**From:** Nolan, Chris <Chris.Nolan@lancashire.gov.uk>  
**Sent:** 17 November 2017 13:37  
**To:** Rachel Horton; planning  
**Cc:** LHS Customer Service  
**Subject:** D3.2017.1053 - 20 Crow Trees Brow Chatburn

Planning Application No: 3/2017/1053  
Grid Ref: 376669 443961  
Proposal: Proposed extension and alterations.  
Location: 20 Crow Trees Brow Chatburn Lancashire BB7 4AA

PROPOSED GROUND FLOOR PLAN
Scale 1:50

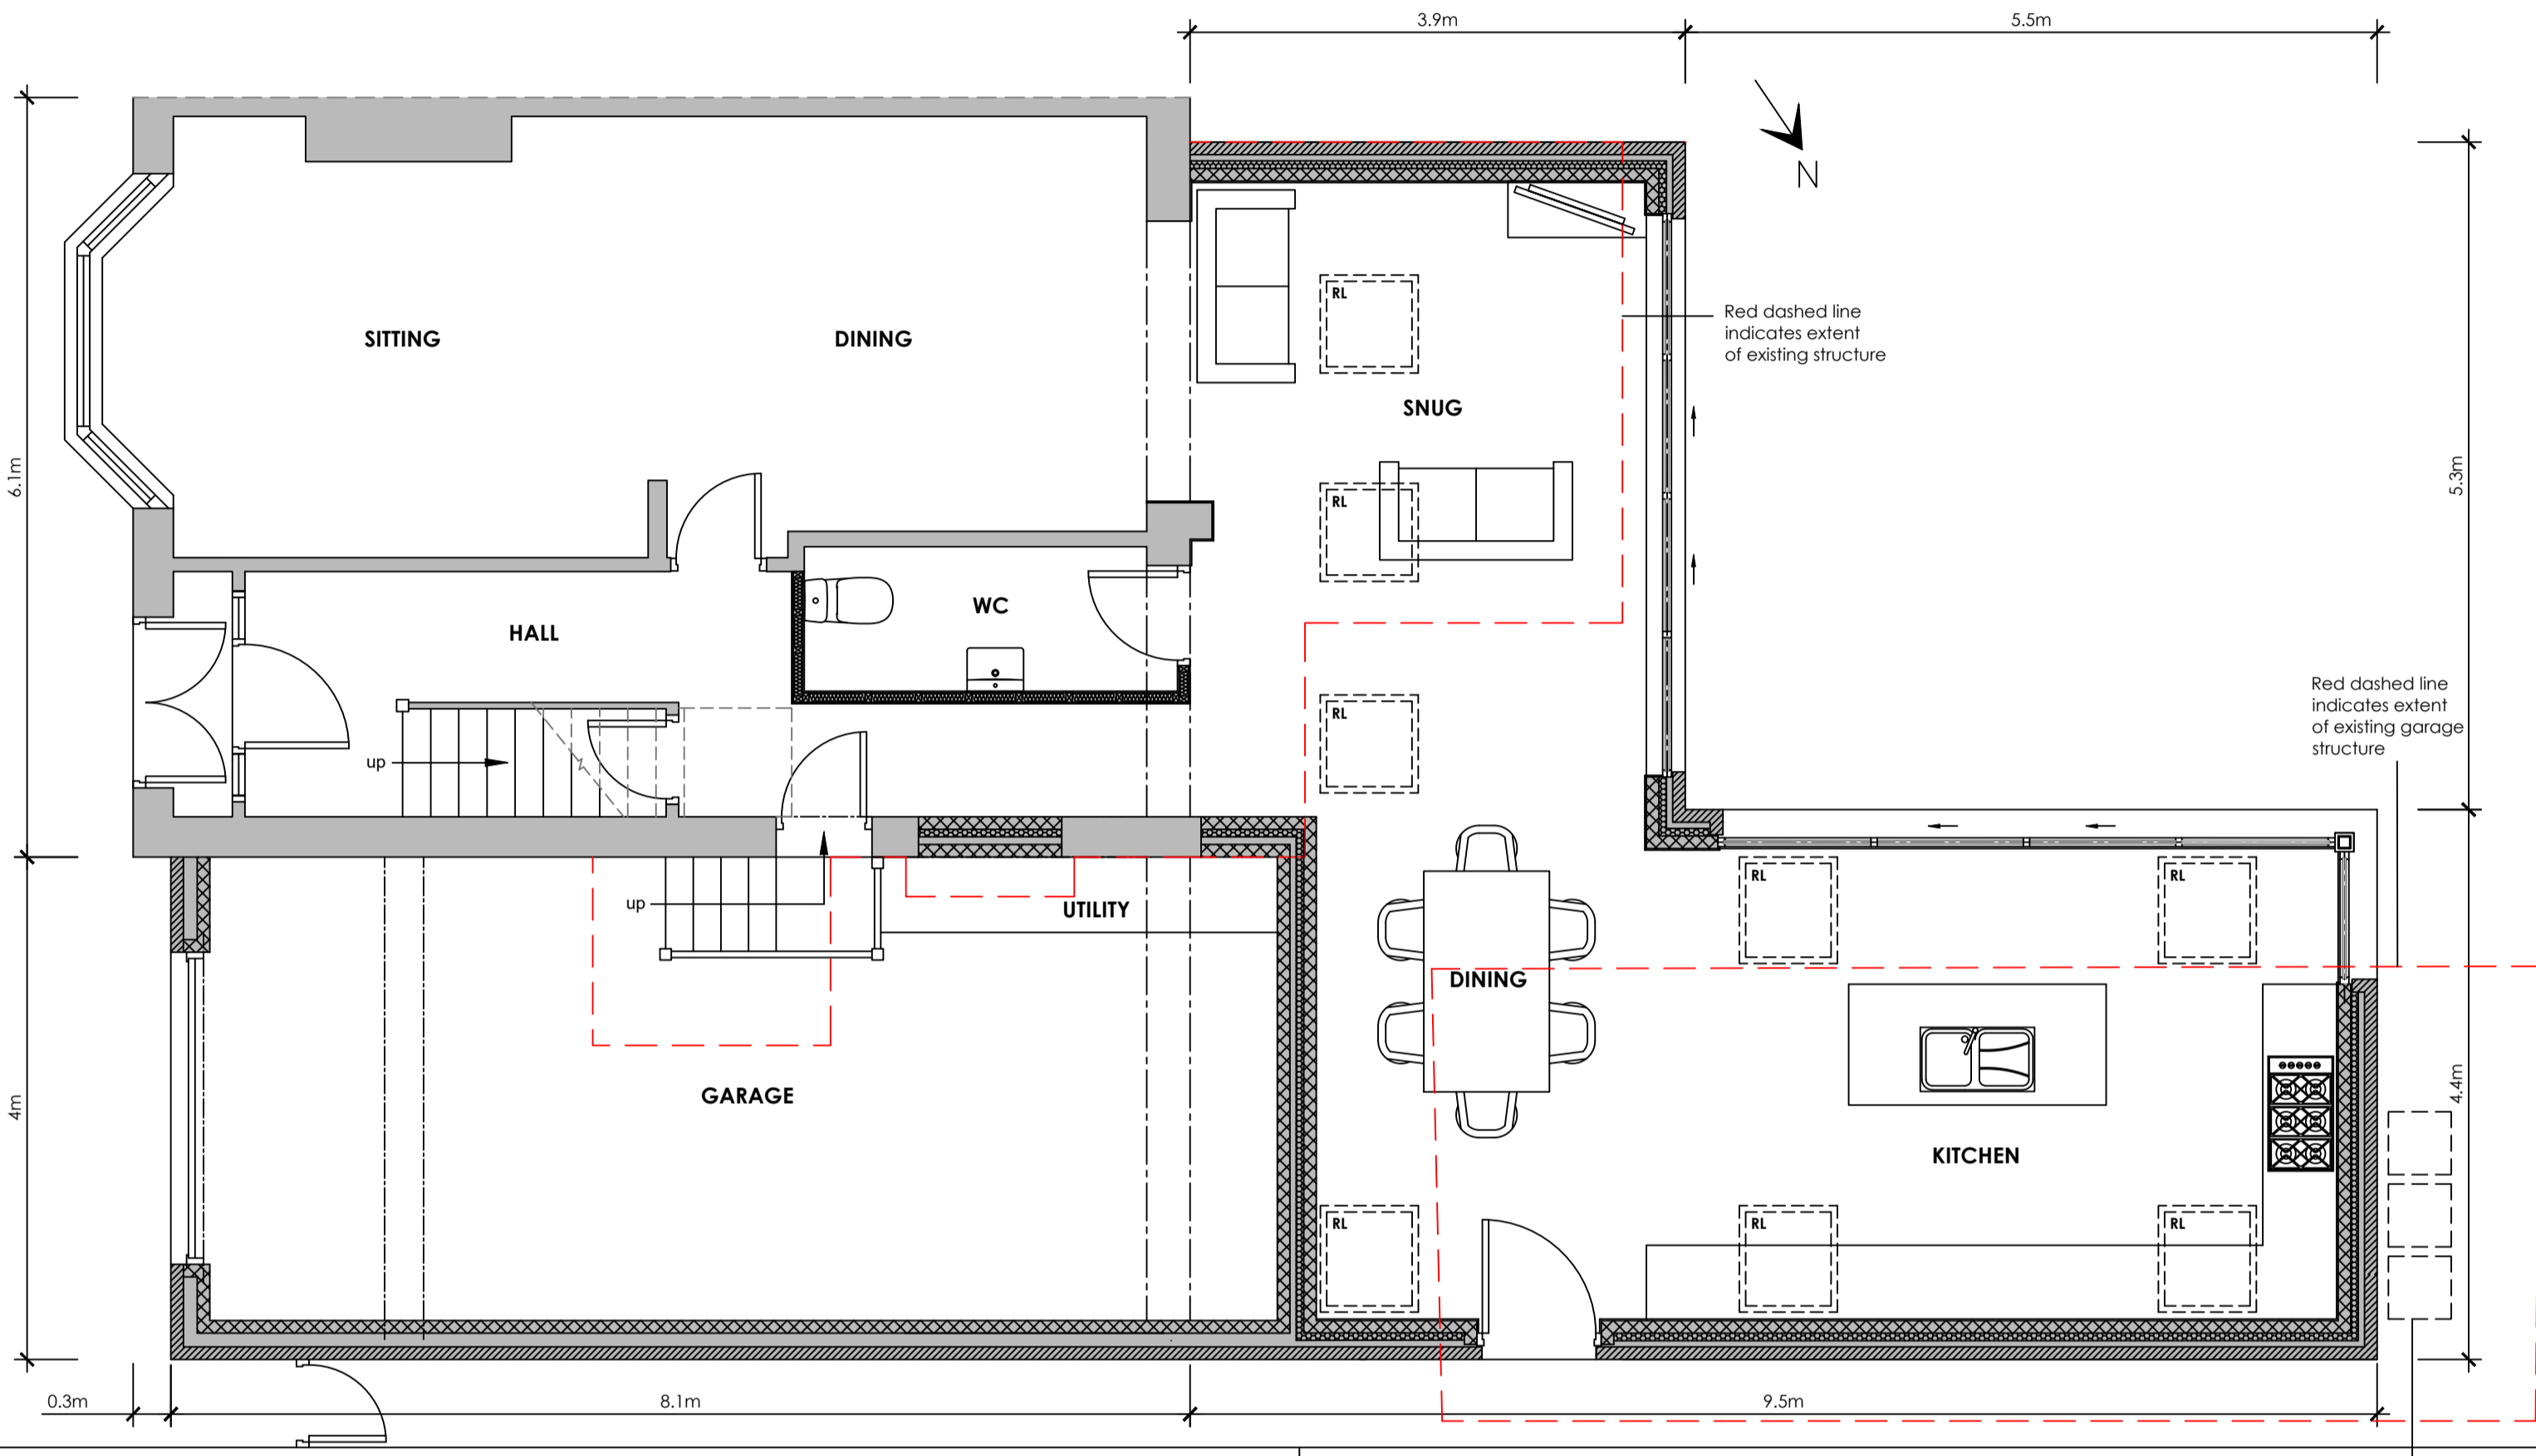
The plans indicate a large garage that will also serve as a utility room but the dimensions will only support parking for one vehicle. The residual drive in front of the house has a steep incline and would not seem to have sufficient length or width to allow for the parking of two further vehicles. The drive is boarded on one side by the property line to the adjoining No.18 Crow Trees Brow and on the other by a retaining structure allowing a level front garden. Discounting the parking need with an allowance of on street parking is an option that is not available as the highway in front of the property is subject to a system of double white lines and therefore parking is prohibited.

PROPOSED SITE PLAN
Scale 1:250

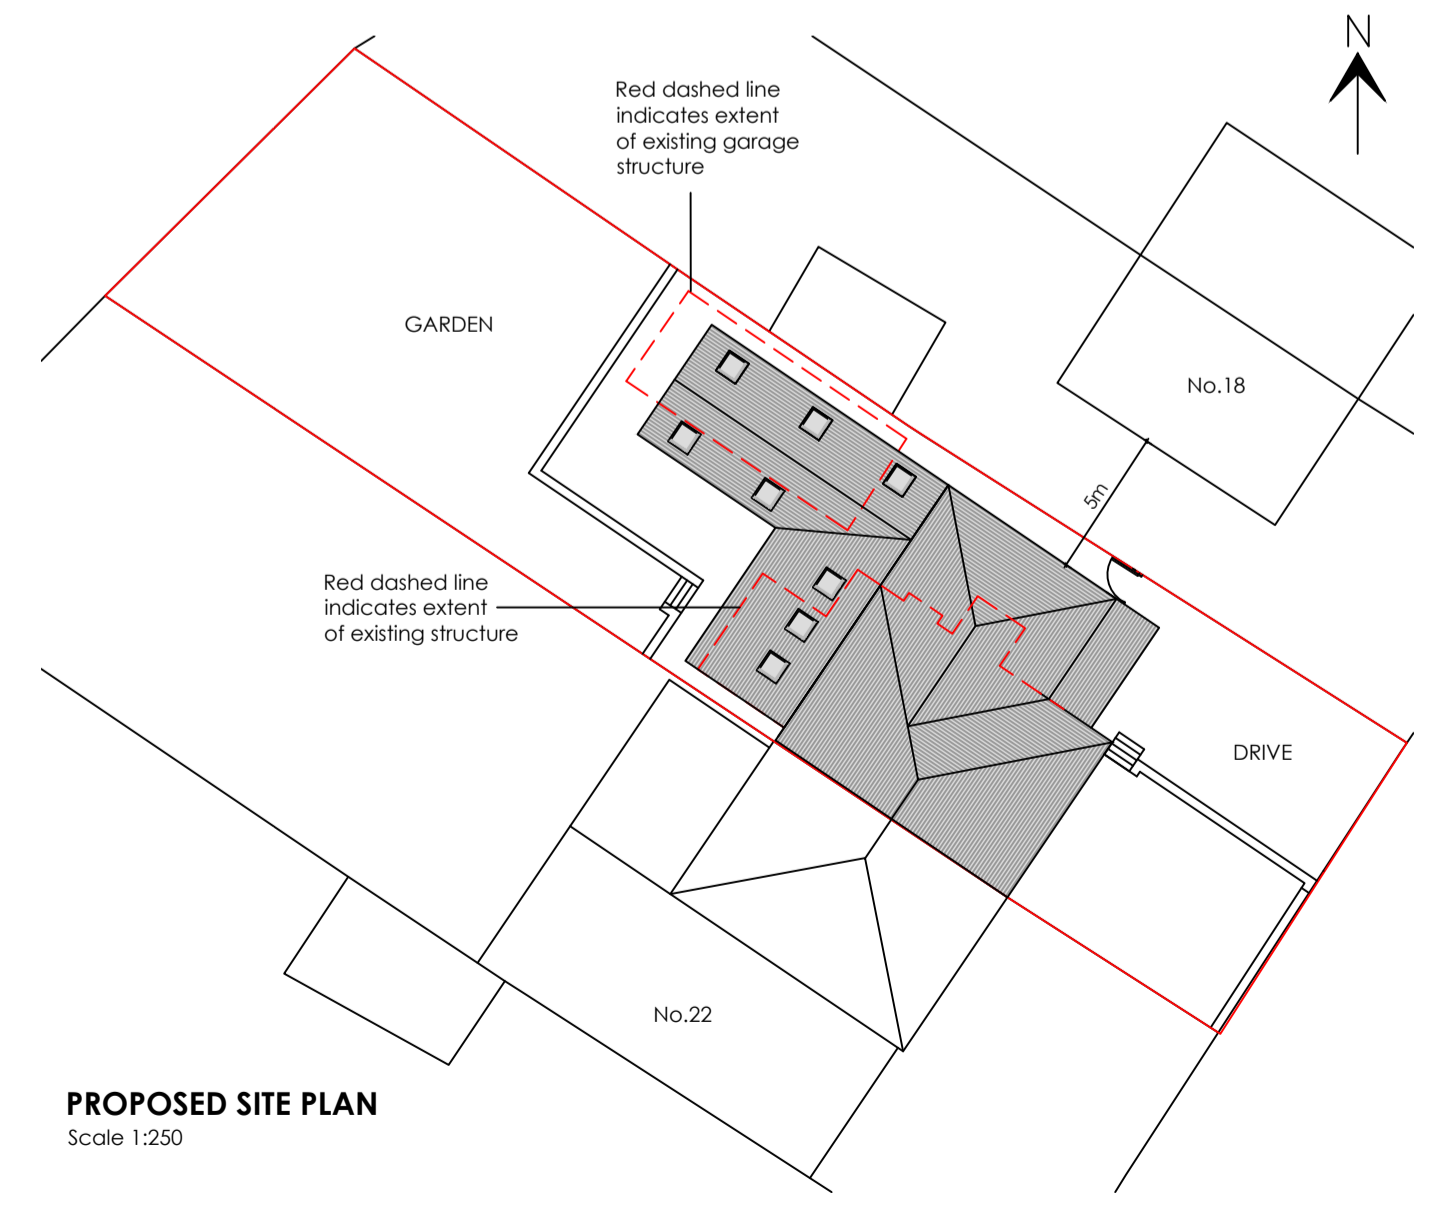
Presently I will have to object to this proposal unless plans can be provided to indicate that there is provision to park three vehicles within the curtilage and that any necessary changes to enable this are included in the proposal. Such Plans need to be a scaled drawing sufficient that the individual bays of 5.6m X 2.4m are able to be verified. For the purposes of this calculation the garage space will be counted as providing one of the required three spaces.
